ENG-EGP22006-R1-FDR.pdf Markup Summary

EGP226

Subject: Stormwater Comments Color
Page Index: 1
Date: 3/14/2023 3:26:33 PM
Author: dotprete
Color: ■
Layer:
Space:
Page Label: 1

SADDLEHORN FILING 5 EARLY GRADING PROPOSED DRAINAGE MAP

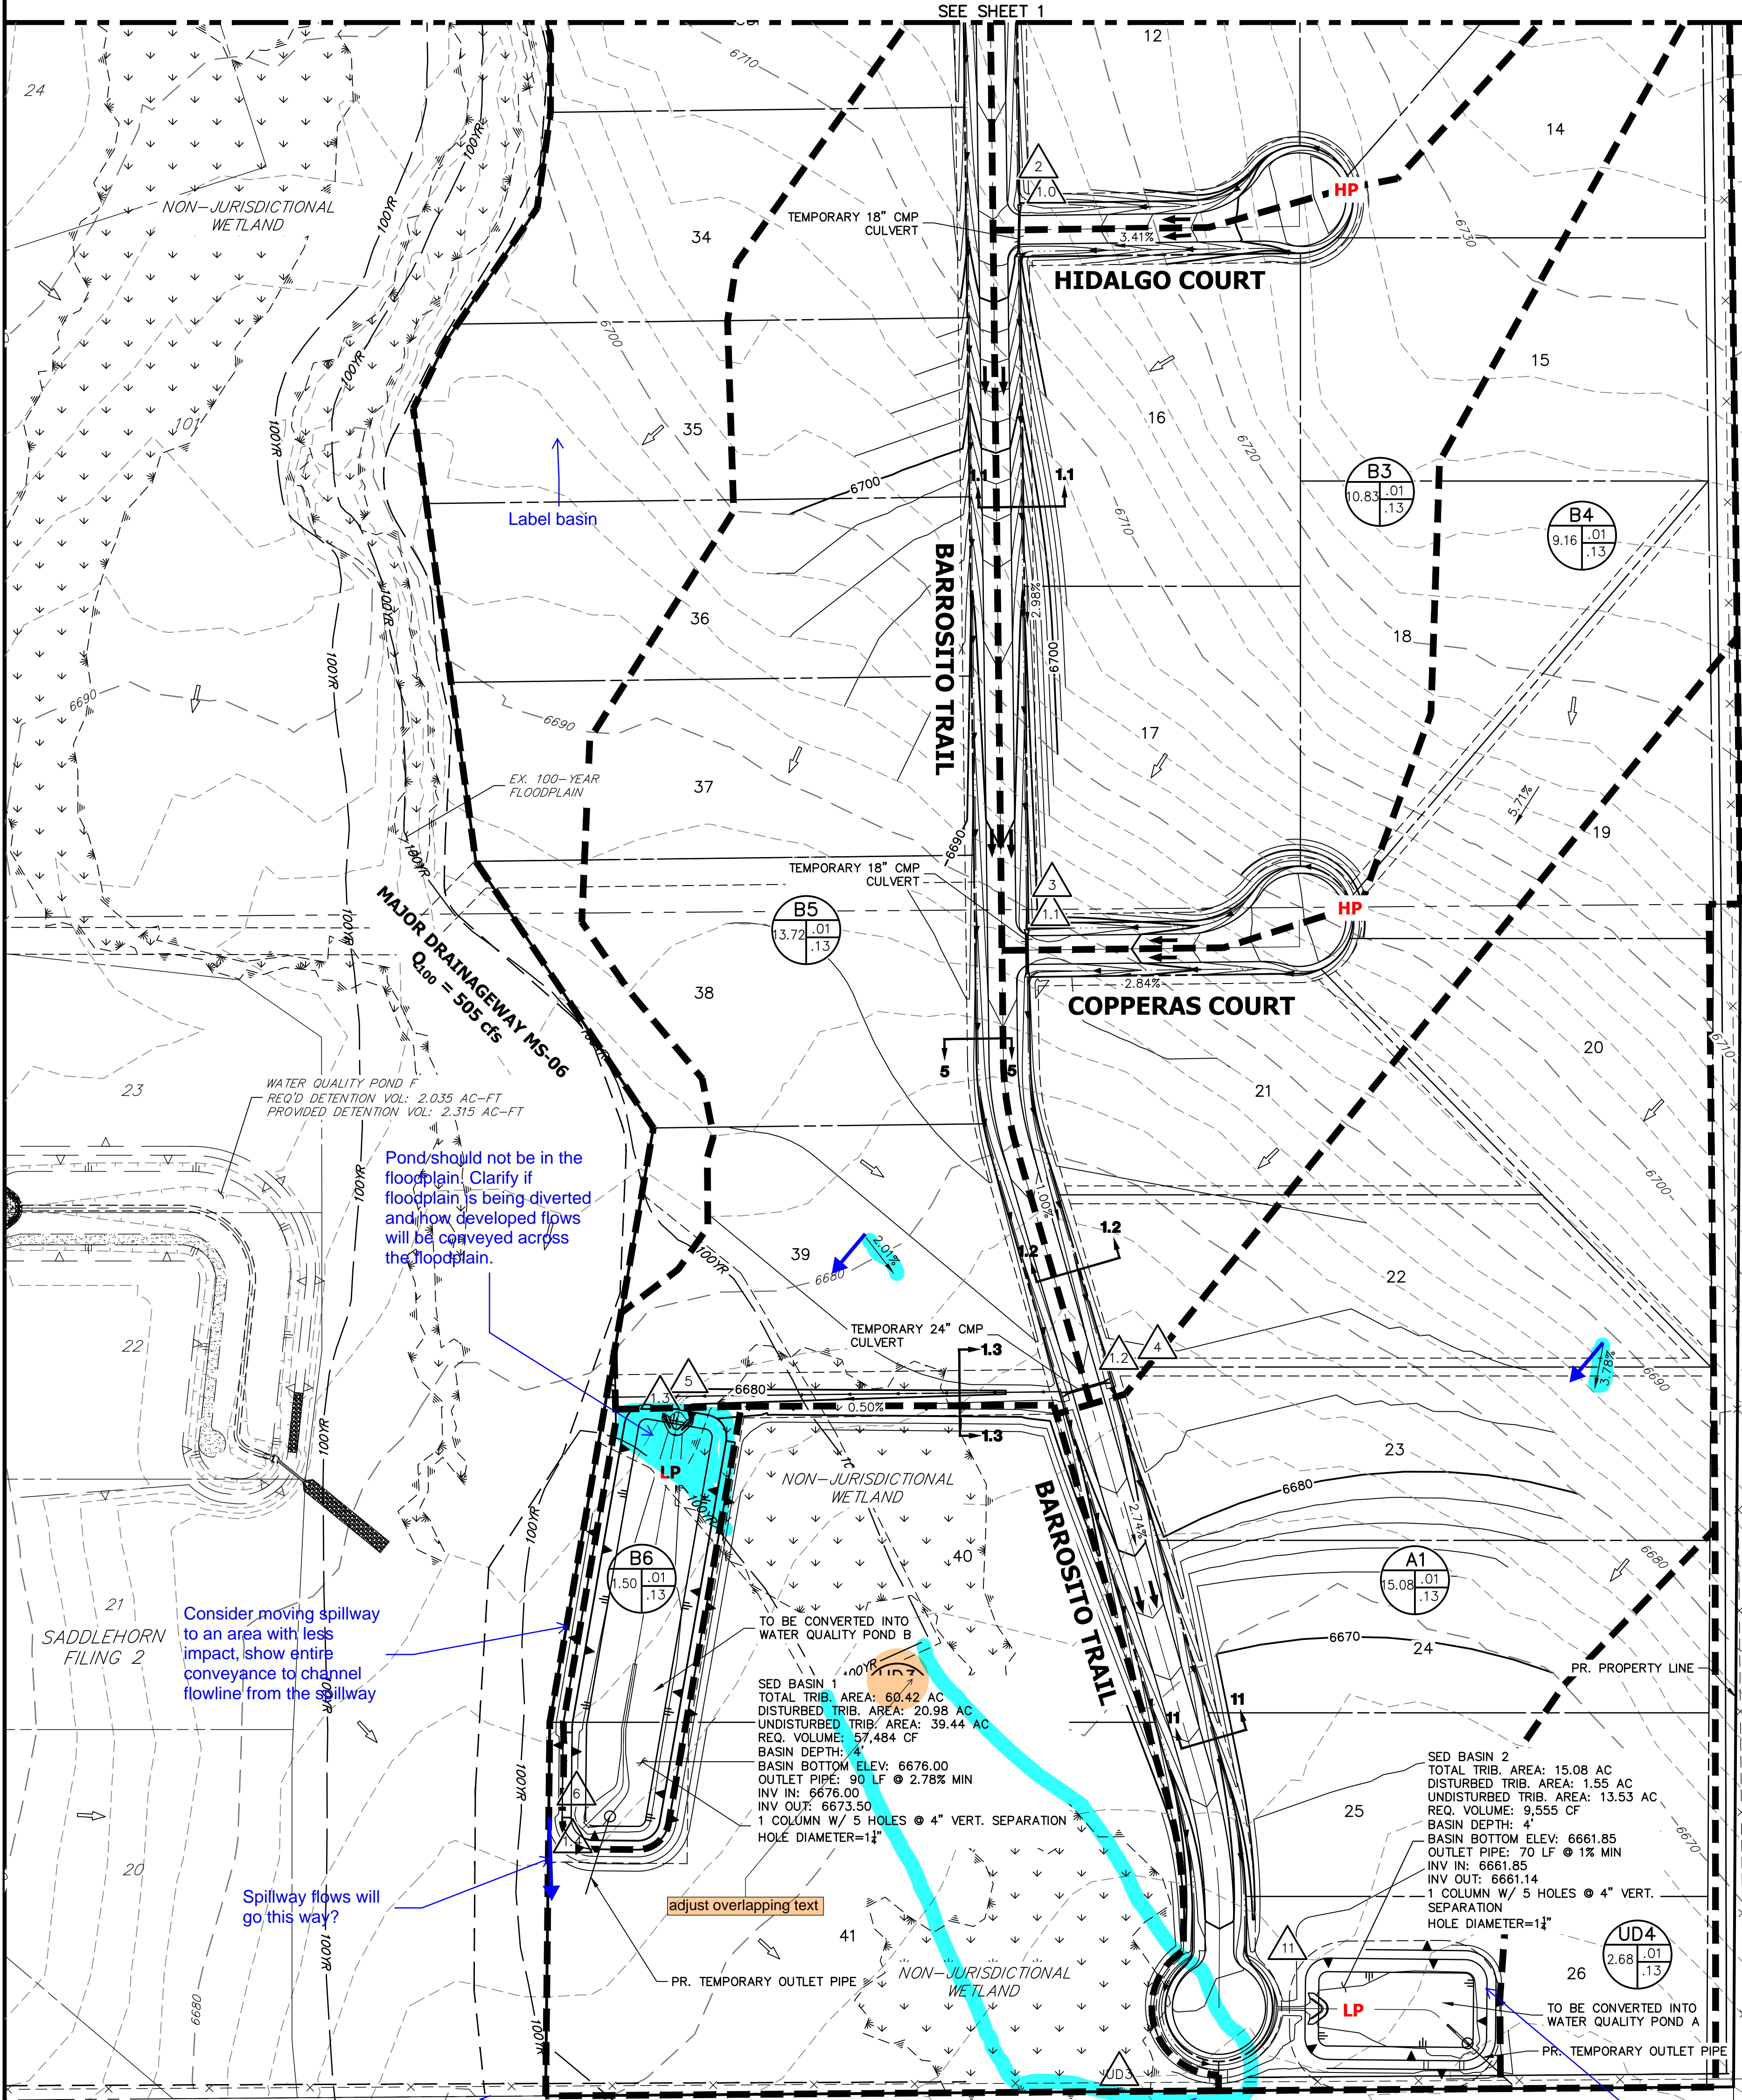
Provide offsite basins

Spillway should be on this corner to minimize downstream impact

Consider moving spillway to an area with less impact, show entire conveyance to channel flowline from the spillway

Spillway flows will go this way?

Missing labels on map

Label basin

complete the floodplain boundary

Will a CLOMR be needed for the increased flow in this channel?

Pond should not be in the floodplain. Clarify if floodplain is being diverted and how developed flows will be conveyed across the floodplain.

SADDLEHORN RANCH - FILING 5 EXISTING CONDITIONS MAP

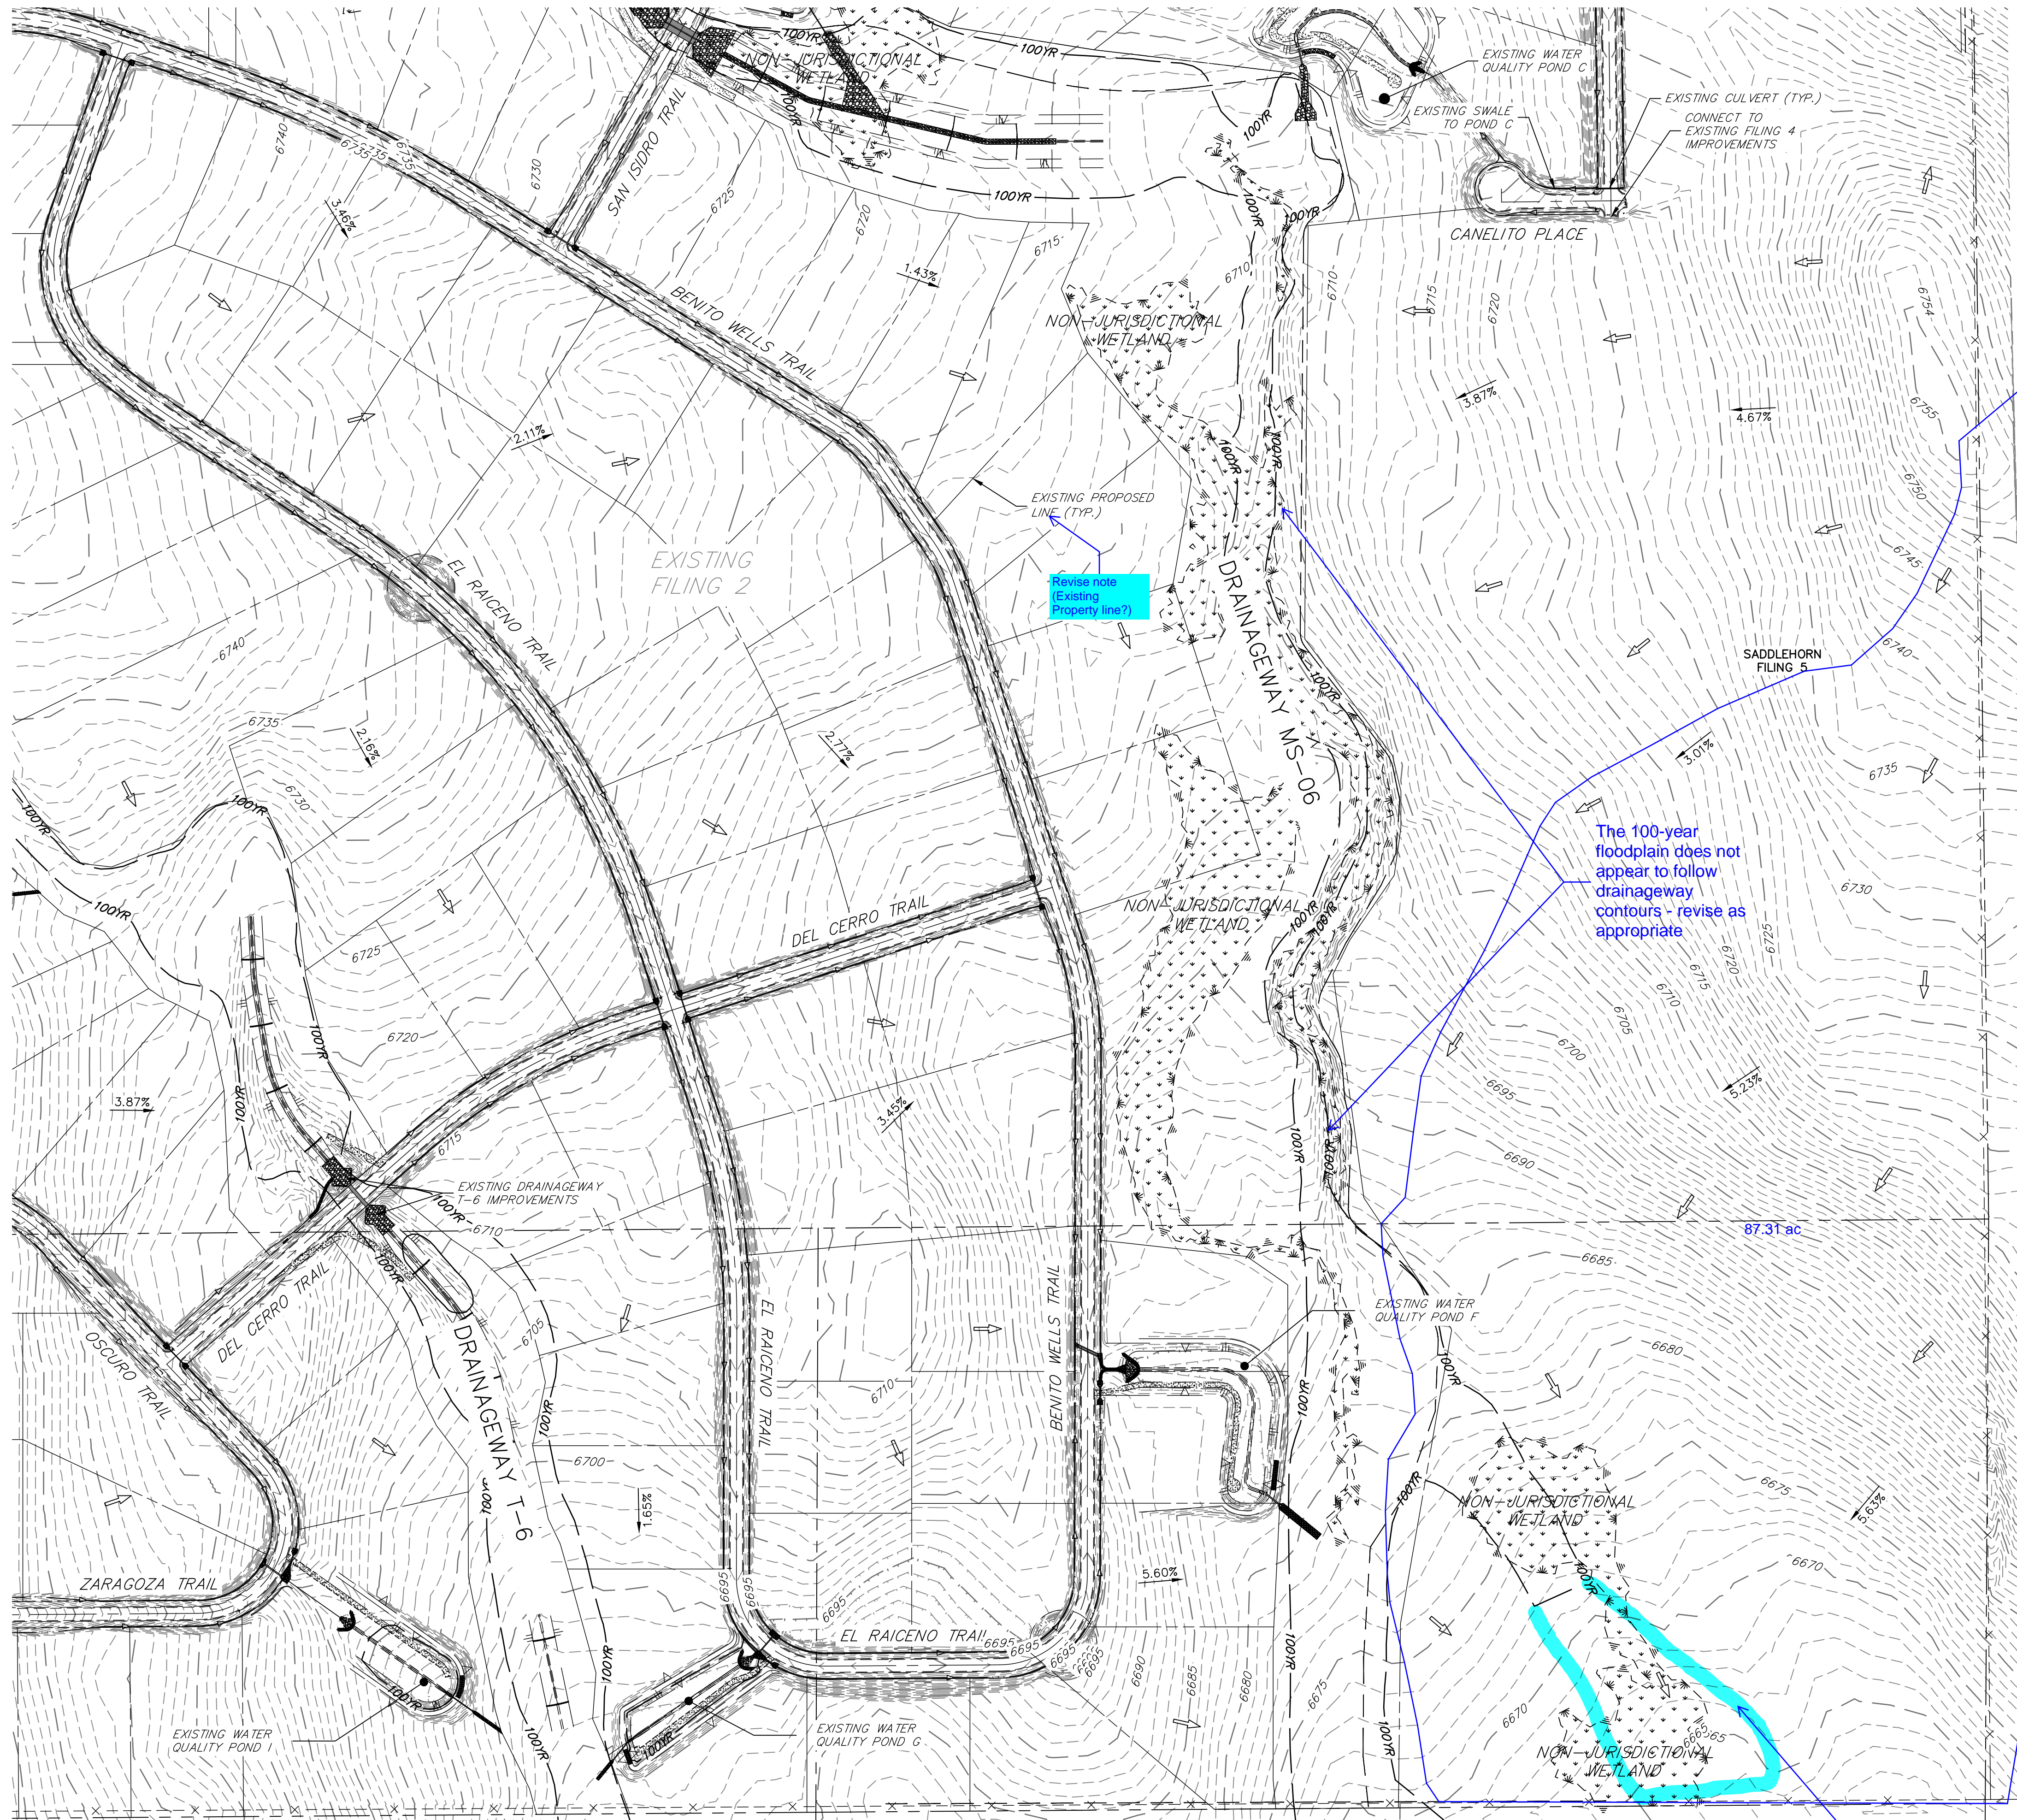
Provide sub-basins, design points, flows, etc. for comparison to developed condition design points

Move map in front of proposed drainage maps.

Label property boundary

Revise note (Existing Property line?)

Address what portion of the basin currently flowing to the south will be diverted to the west through the proposed detention pond and what the impacts to the channel will be. This will be a larger issue with the final plat.

The 100-year floodplain does not appear to follow
drainageway contours - revise as appropriate

show the rest of the 100-year floodplain to the
property line
